WILLIAM A. PERSON, P.E.
CONSULTING ENGINEER

August 29, 2019

Re: Plan Review
Detached Garage
Jay Rauer
5674 Cokesbury Rd.
Fuquay Varina, N.C.
30'x40' W/10'x40' LT

TYPICAL BUILDING SECTION
NTS

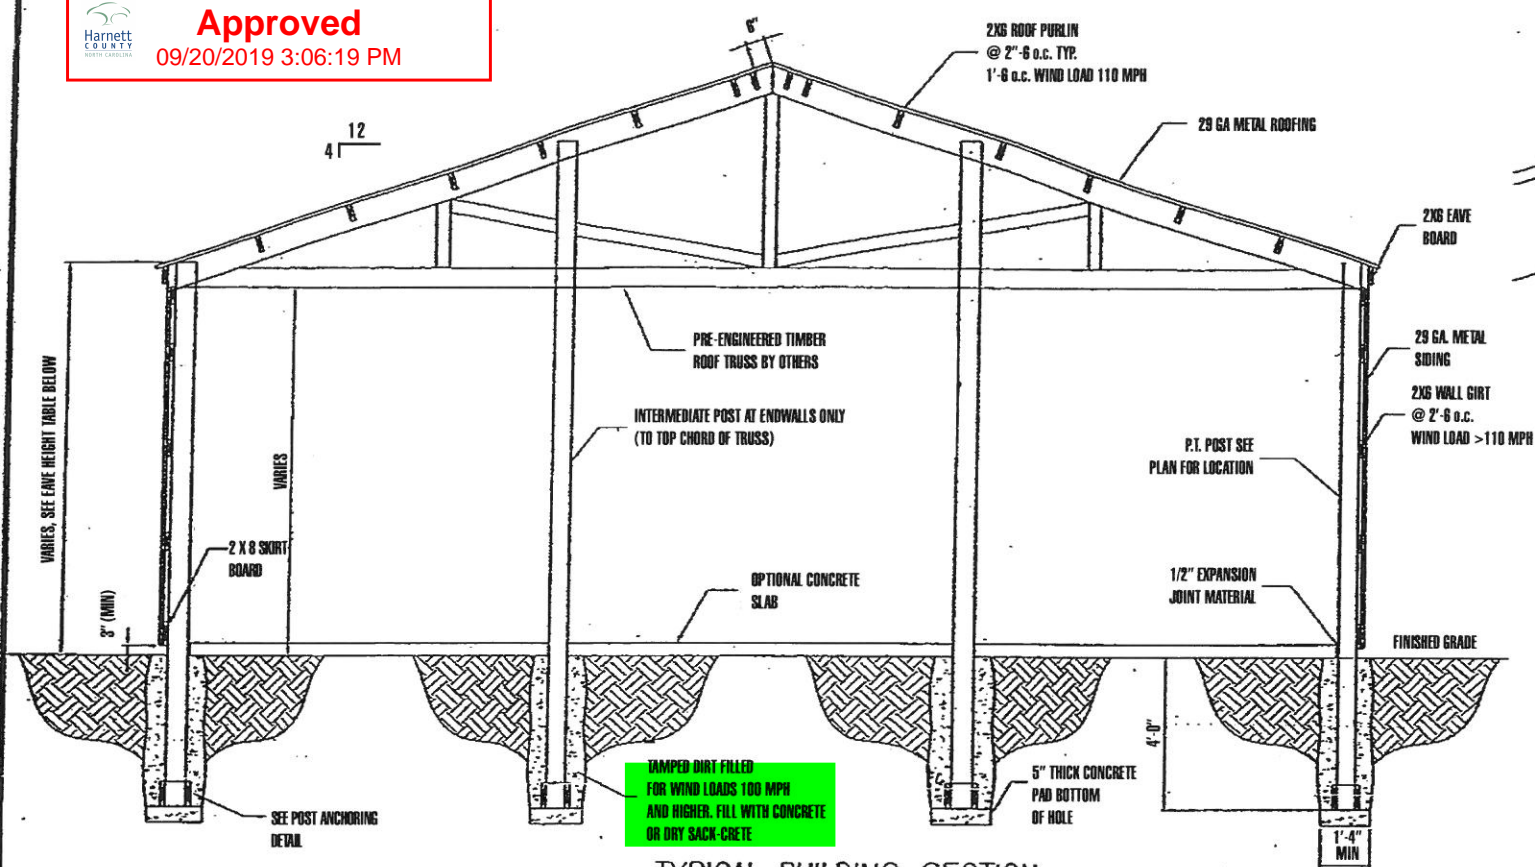
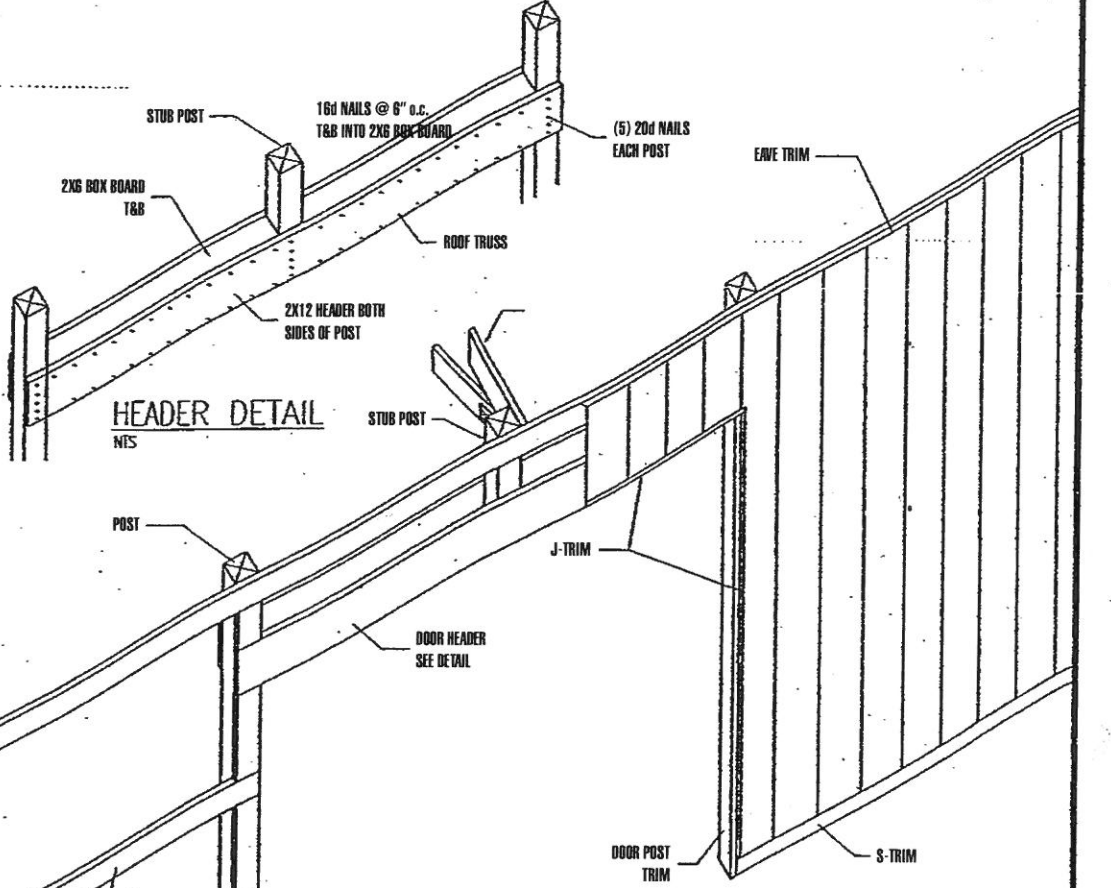
The lean to shall have 2x8 rafters at 2' on center, posts shall be spaced at 13'-4" on center with a 2-2x12 rafter support beam.
